From: Elaine Walby on behalf of Planning.Responses
Sent: 22 June 2026 11:12
To: Planning Scanning
Subject: FW: Mr. Harry Chalk Snr. Planning Officer Re: FG/47/26/PD The Haystack Sea Lane Ferring BN12 5EP

Dear Harry, I represent Ferring Conservation Group and wish to make the following submission on behalf of our members in respect of application FG/47/26/PD - The Haystack Sea Lane Ferring BN12 5EP

SECOND FLOOR PLAN | PROPOSED

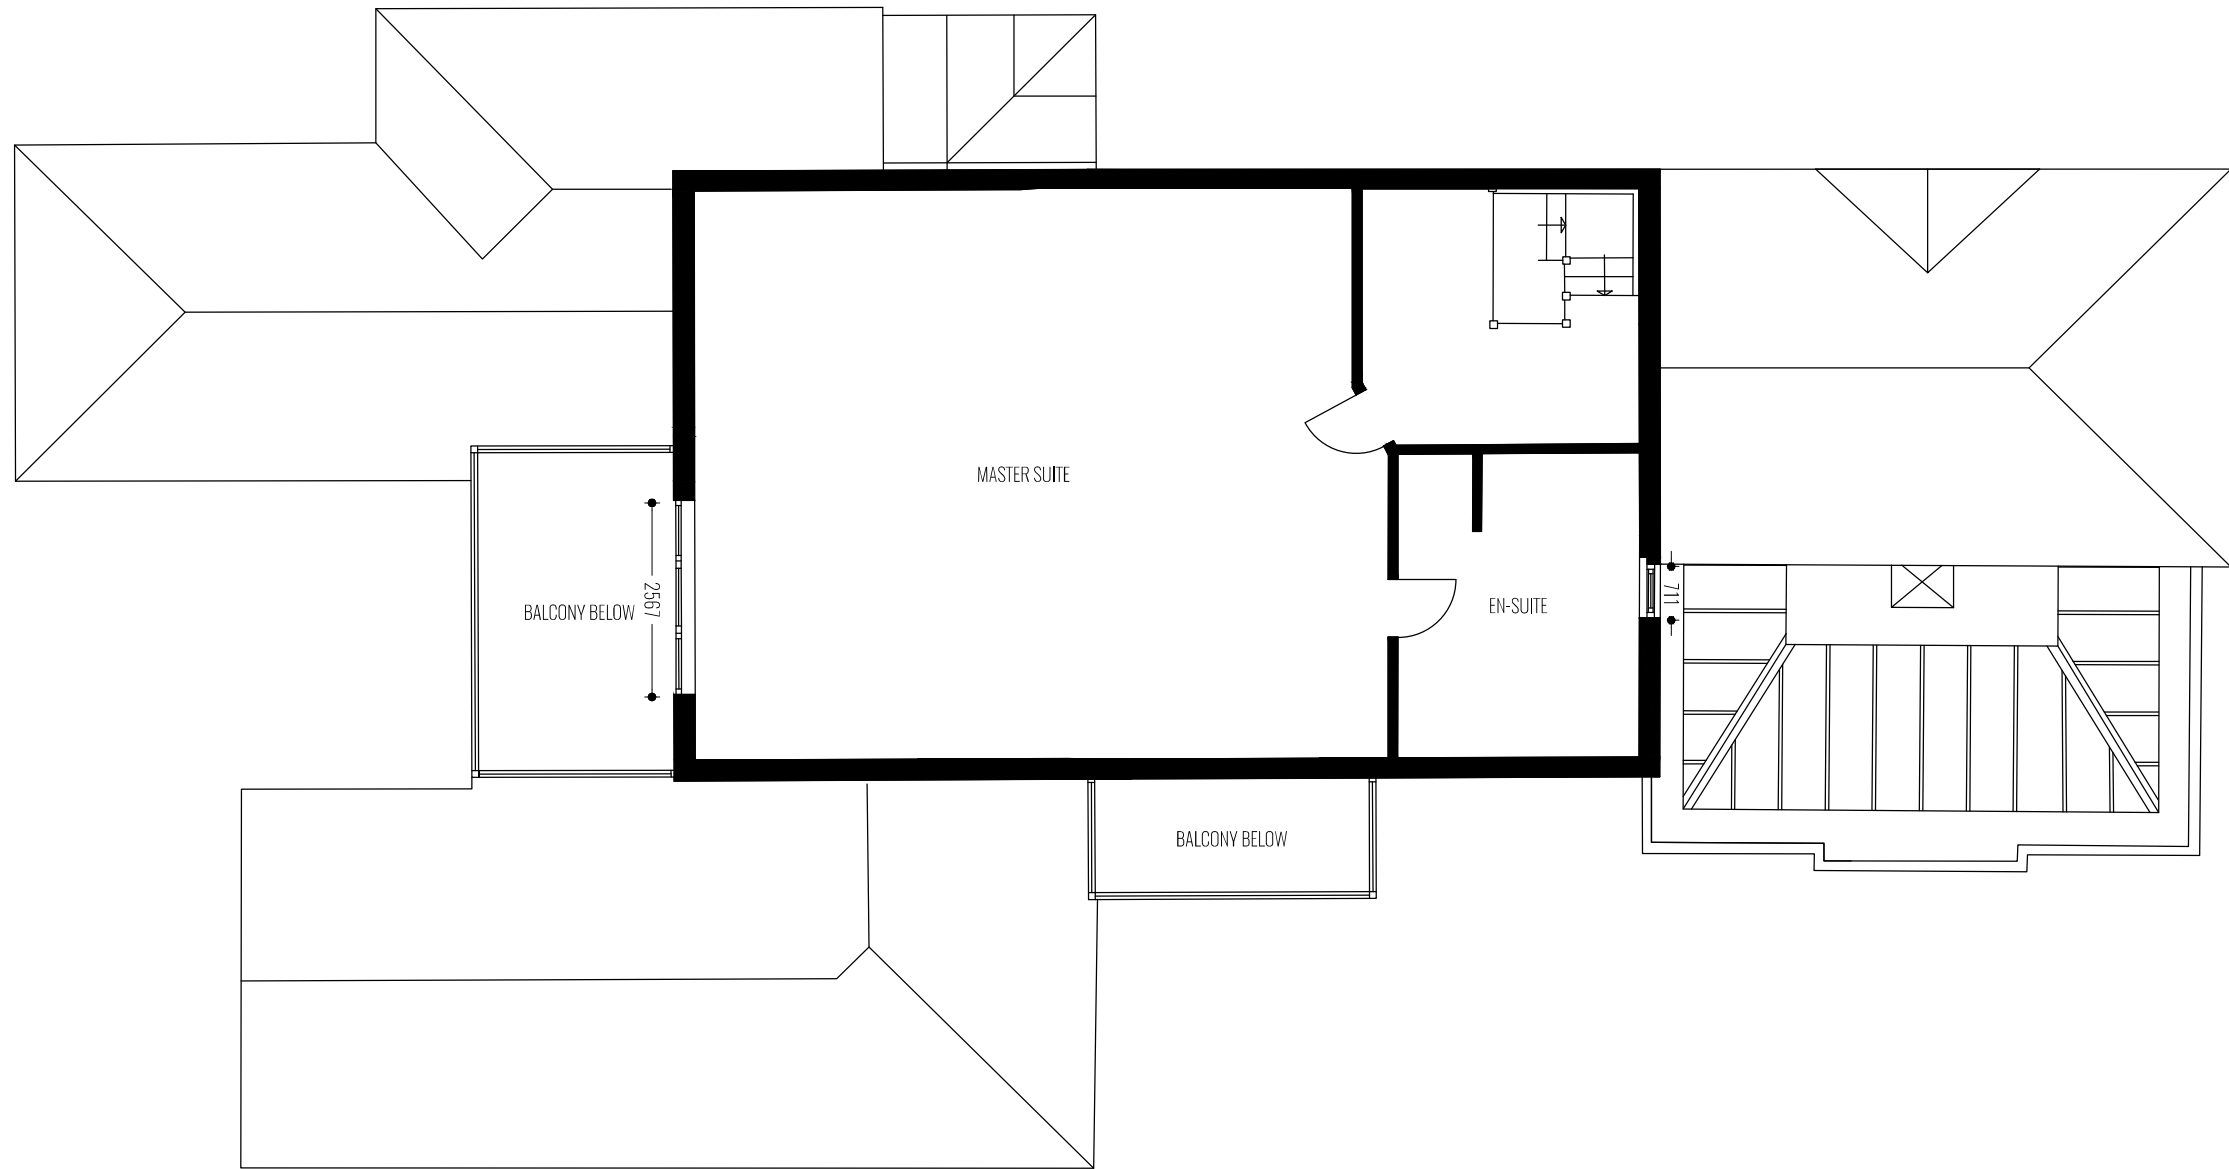
The proposal seeks to develop the existing traditional styled dwelling into a three-storey building (plus roof space). Windows at the third storey level look out to the east and west. The impact of proposed third level from the south presents a large wall above the tree line and a direct, dominant visual impairment to the southern Gap and the views northwards to Highdown Hill from public footpaths and the greensward of the popular beach area. Such a large-scale feature in the rural setting of the southern Gap is out of keeping and conflicts with the designation of the Gap.
